Date: 01/04/2021

Re: **Moisture Concerns**
Location: Lot 10 Mason Pointe (76 Rawls
Farm Lane, Fuquay-Varina, NC)
JDSfaulkner Project No.: RDU2100032,
RDU2100467, RDU2100691
Date of Inspection: 01/04/2020

PARTIAL CRAWL SPACE PLAN 'C'

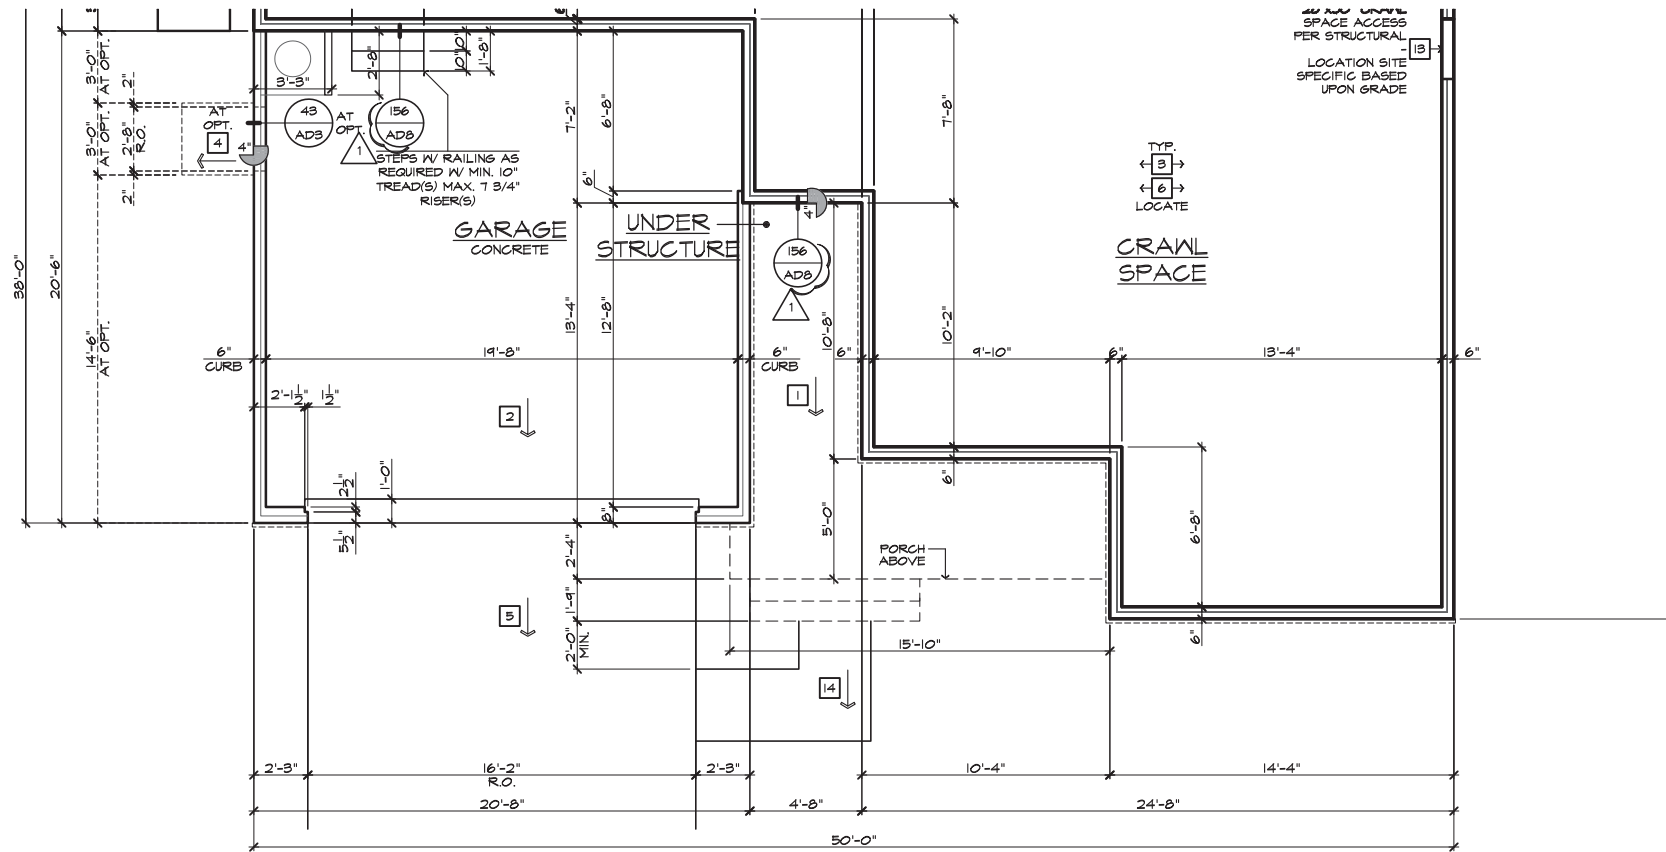
The client requested evaluation of the saturated soils occurring in the crawlspace approximately 3' behind the right rear garage wall. An area approximately 10' by 10' has soft and wet soil.

Based on our on-site evaluation and review, we recommend installing an interior crawlspace French drain system at the site of excessive moisture to collect ground water. The French drain system shall be placed at an adequate depth to capture the excessive groundwater. The French drain shall be run to the exterior and piped away from the foundation.
